CITY OF ALBUQUERQUE

June 6, 2014

**Re: FedEx Ground Overall Grading and Drainage Plan
Engineer's Stamp Date 5-19-14 (K09D026A)**

FEDEX GROUND
ALBUQUERQUE, NM
OVERALL GRADING
AND DRAINAGE PLAN

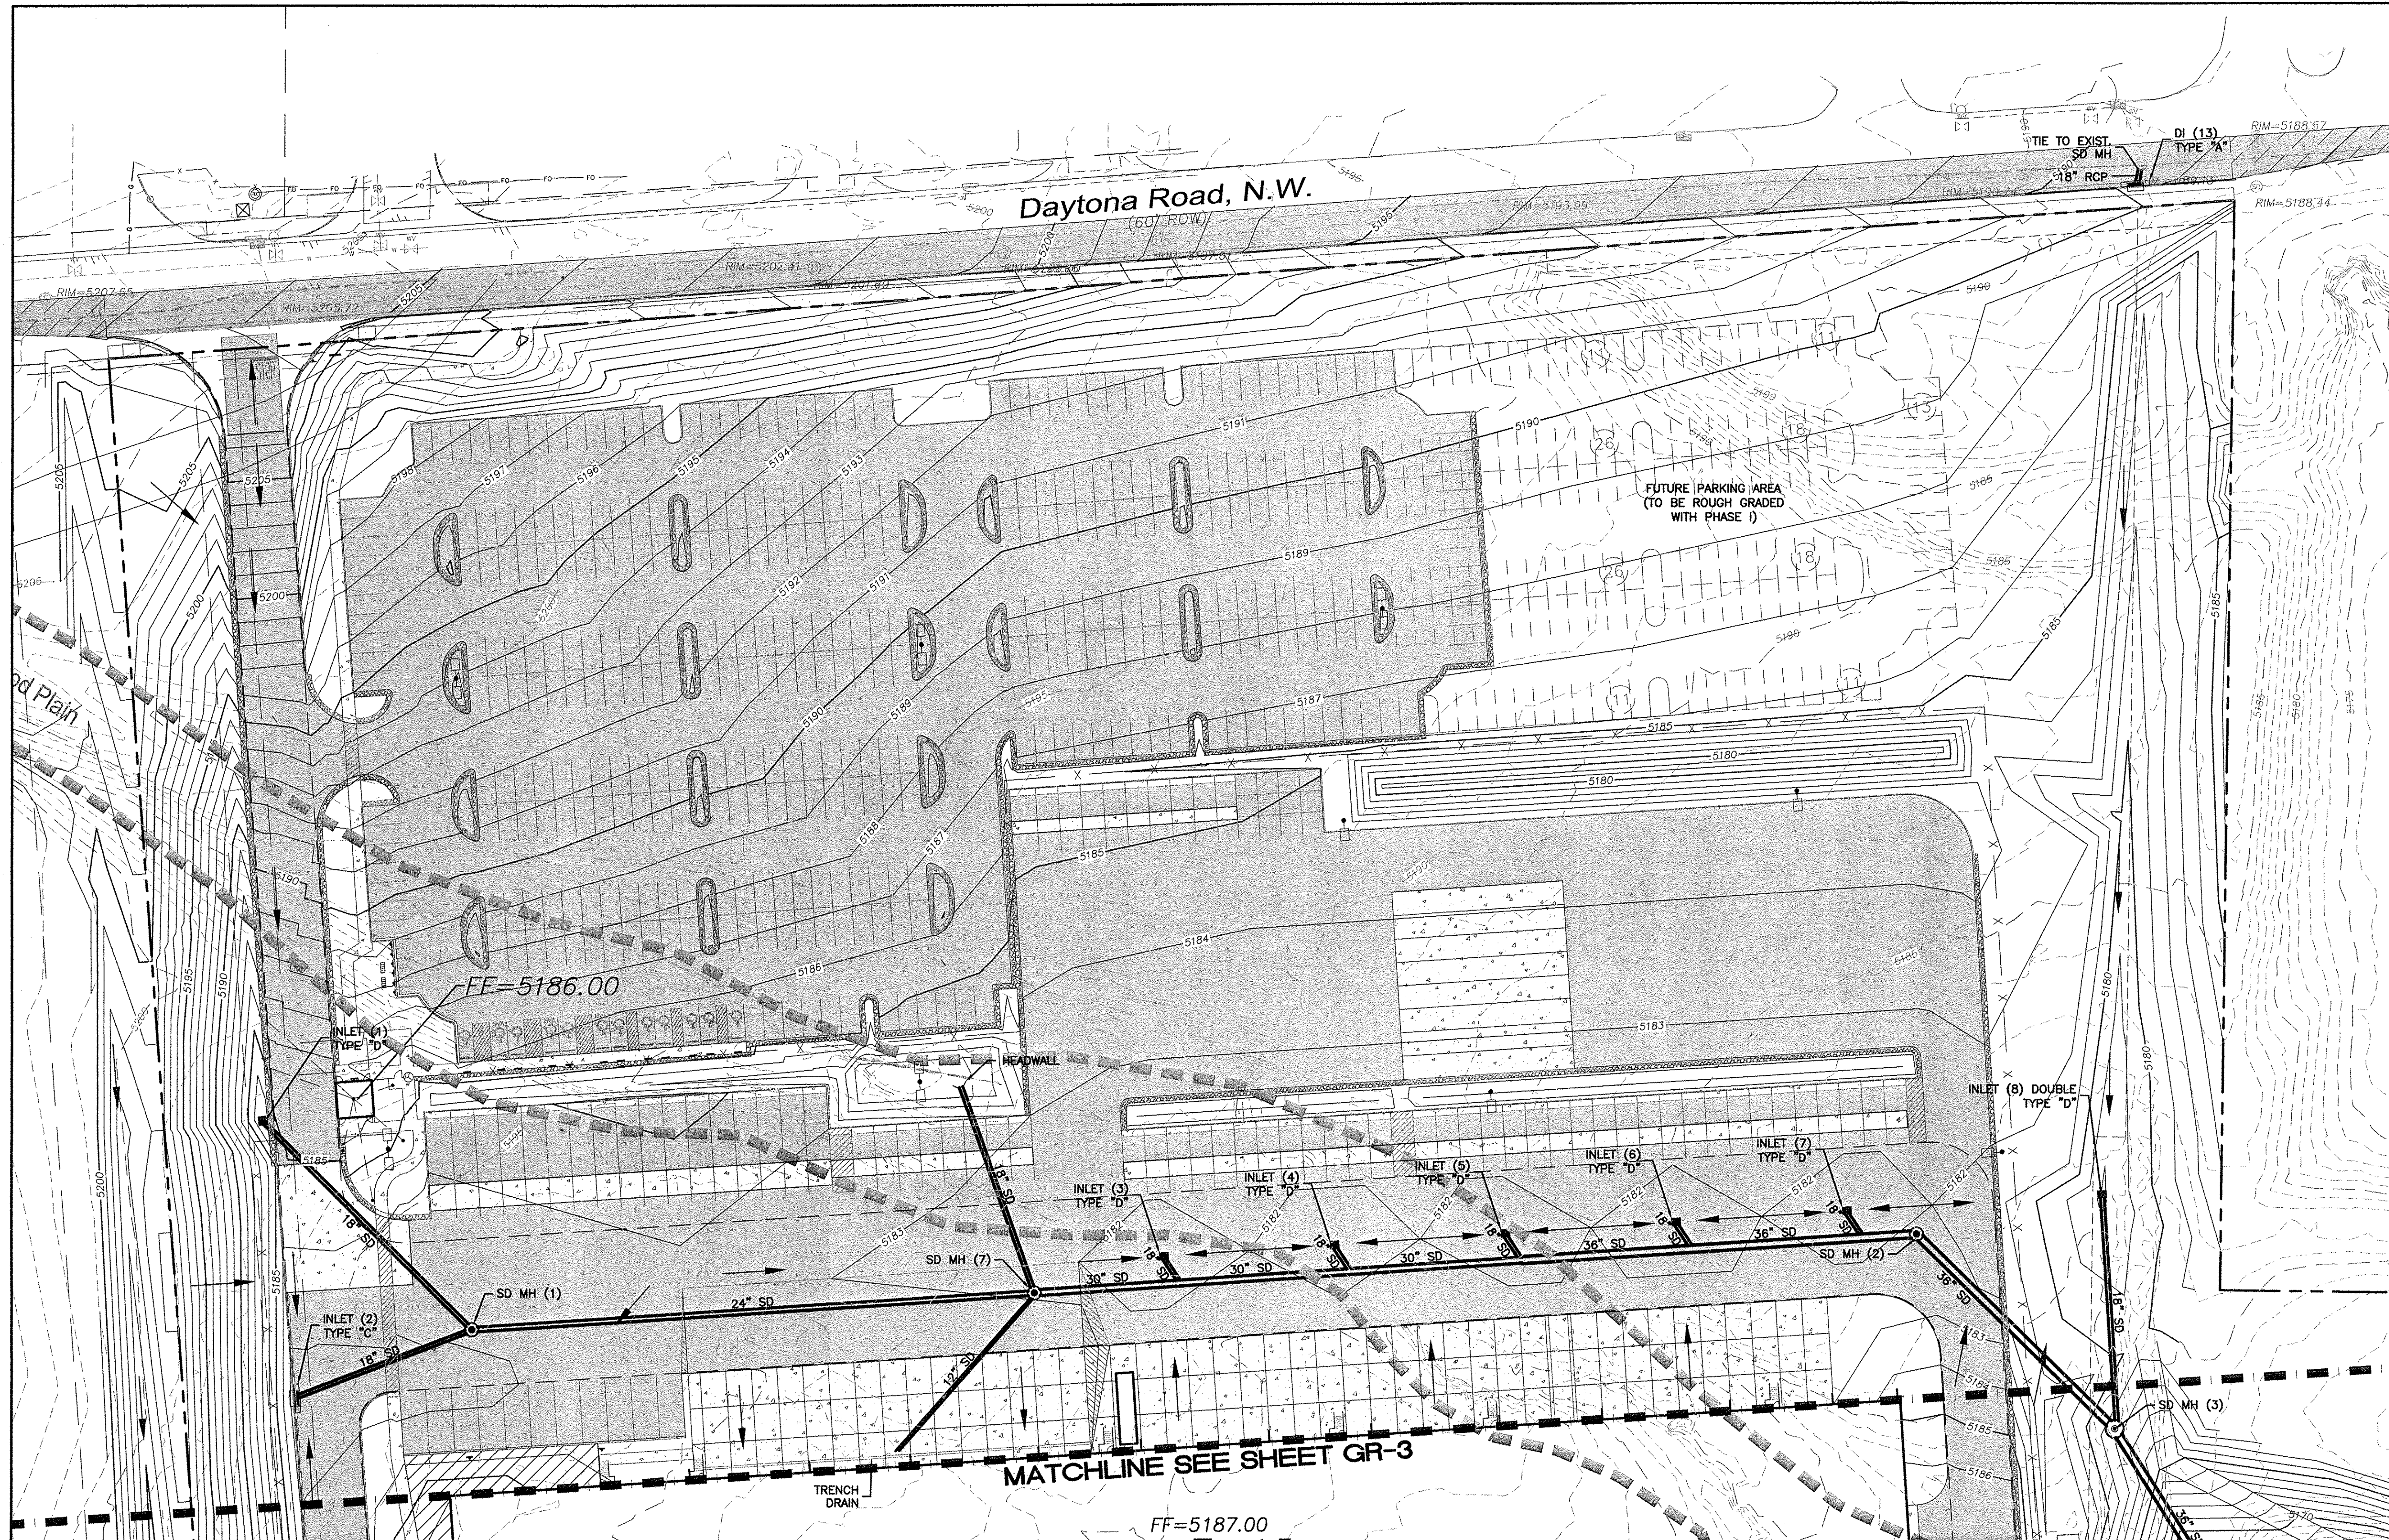
2. Does the Los Volcanos storm drain have capacity to accept diverted flows?
3. Show/state that Pond 5 has the capacity to accept flows from the graded site as Land Treatment C. Rough calculations show that it has capacity.

4. Is Pond 5 to be used for sediment control as part of the SWPPP? If so, will you be plugging the 3-8" pipes?
5. It is acceptable to the Dept. of Municipal Development to grade in Pond 5 if it is privately maintained. The City's agreement with AMAFCA will have to be superseded. This could occur later in the process with acknowledgement of maintenance responsibility by the property owner.

6. A Floodplain Development Permit is required prior to grading. Hydrology will e-mail one.
7. This plan proposes grading and construction of storm drain on an adjacent parcel. Is the adjacent parcel B12? Does the west lot line currently exist in this location? Written permission from the adjacent land owner is required. An easement may be required.

8. A small pond should be graded in the southeast corner of the site to contain flows prior to the construction of Inlet 12.
9. It is not clear how long it will take to approve Mr. Easterling's revised drainage report as it was modeled in HEC-HMS which requires additional research. Hydrology requested Mr. Easterling to submit a parallel report in AHYMO for comparison. It is not clear if he will submit it. It may be prudent to submit your own revised DMP in AHYMO to expedite the Site Plan for Building Permit approval process.
